From: Paul Cann
Sent: 28 February 2018 13:51
To: Planning.Responses
Subject: RE: Planning Consultation on P/20/18/DOC

Condition no.3

APPLICATION NO: P/20/18/DOC

Registered: 19-FEB-18
Site Address: 7 Webb Close Pagham PO21 4XB

PROPOSED DRAINAGE PLAN

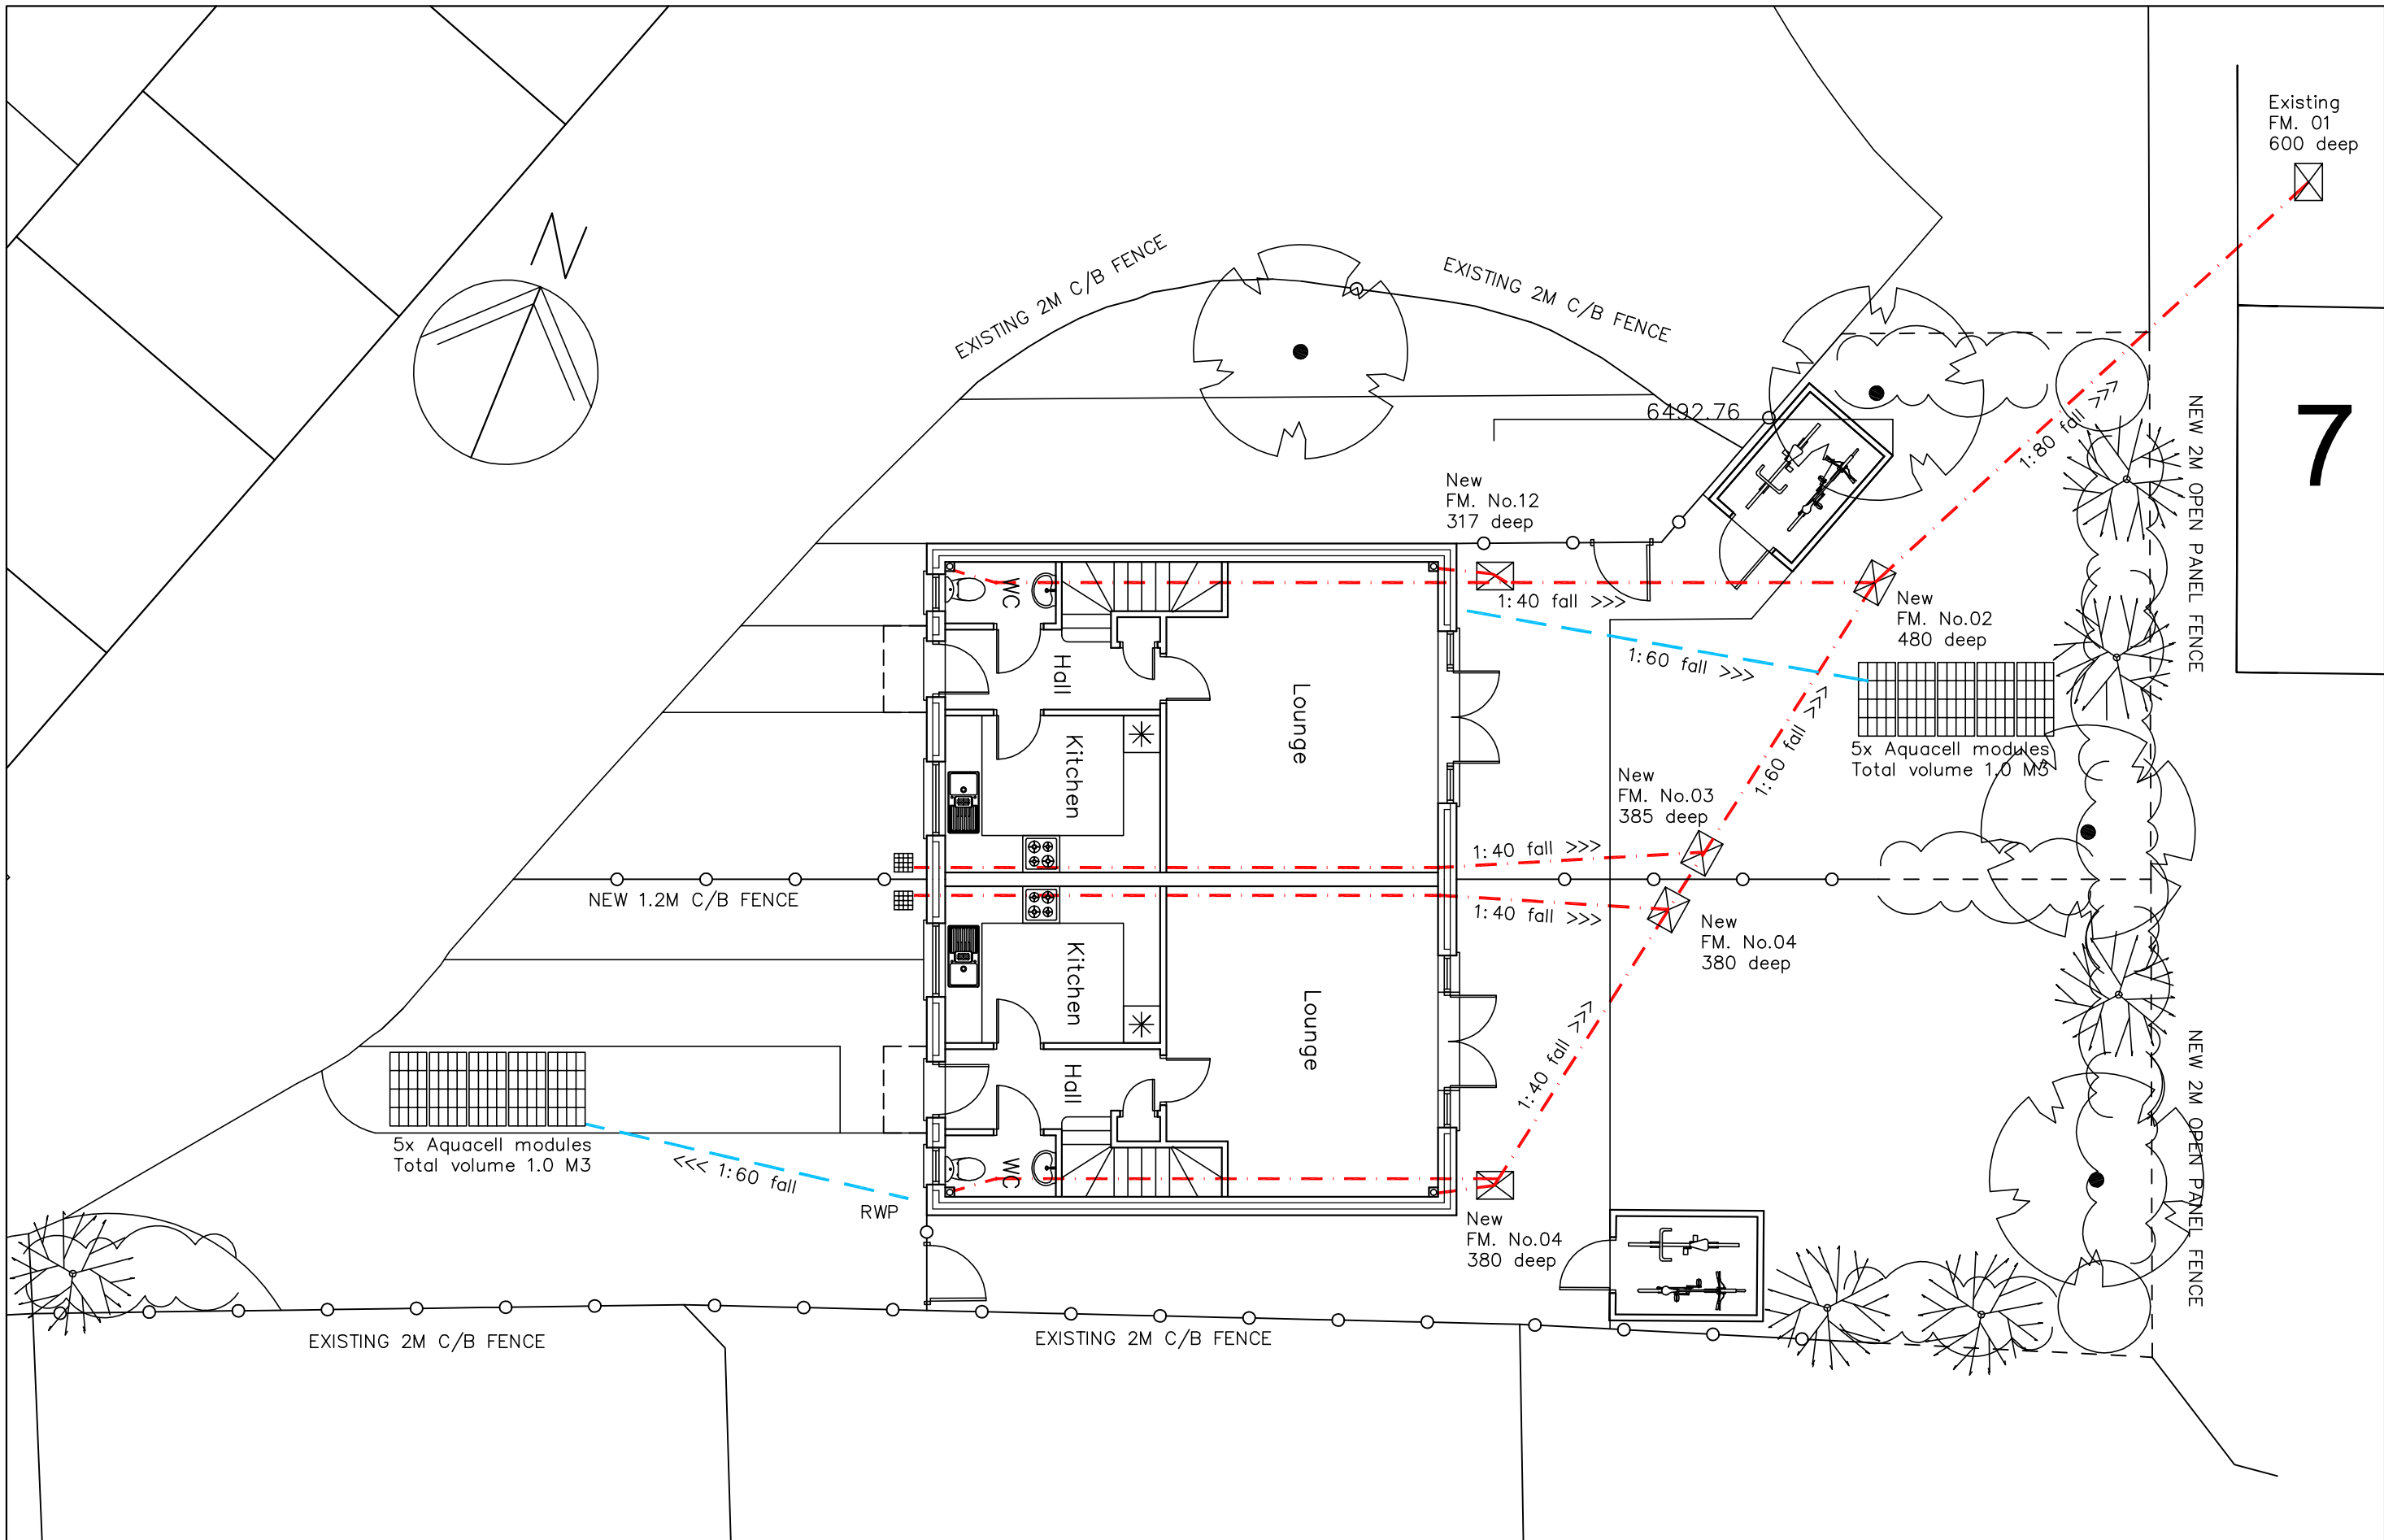
1. The applicant has not provided winter groundwater monitoring data or winter percolation testing data to BRE365, to support the design. This is critical.
2. The winter groundwater monitoring should coincide with high tides due to the possibility of tidal influence.
3. The drainage scheme will need to be fully detailed ie. levels of incoming pipes/soakaway base levels, etc. Permeable pavements will need to include base/formation levels and finished levels.
4. Catchpits are required upstream of soakaways.
5. Full construction details for the soakaways, catchpits and permeable paving are required.
6. Supporting hydraulic calculations for the soakaway and permeable paving designs, to prove that the 1 in 100 year storm event plus climate change can be accommodated within the systems.

Bearing in mind the above, I am unable to recommend discharge of the condition at this time.
